Application No: WA/5/22/PL
Site Address: Morelands Arundel Road Fontwell BN18 0SB
Description of works: Demolition of 1 No dwelling & erection of 5 No dwellings with associated car parking and access. This site is in CIL Zone 2 and is CIL Liable as new dwellings.

Thank you for your internet representation made on 12th February 2022 which has been recorded as an objection with the comments as follows:

Figure 15: House Type B, front elevation – see KD.1000_A.202

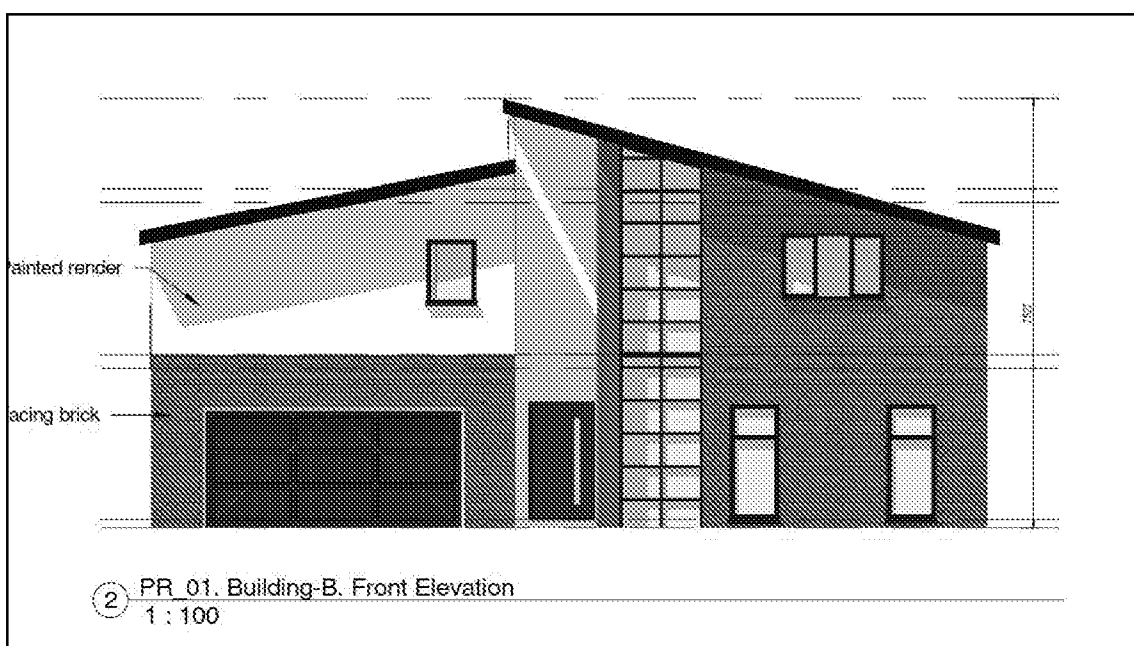
There is insufficient parking; cars will spill onto Arundel Road - causing congestion if A27 by-pass plans are approved. House design not in keeping with semi-rural area-more suited to urban/city situation. Balconies not appropriate to such dense development and are against Arun's design guide. Floor to roof windows provide light pollution in contravention of Dark Skies Policy VE8 of Walberton Neighbourhood Development Plan (2) - so close to National Park. Arboriculture report infers hedges are low value; this is not the case, they are a wildlife corridor for birds, mammals, and particularly, dormice that were detected on Dandara's survey. Bats not detected last year due to displacement after Dandara site policy of ripping out hedges! They have, in previous years, been regularly seen flying around the area. Why does the A.201 title box stipulate proposed development of 6 dwellings, and not the 5 shown on plan?
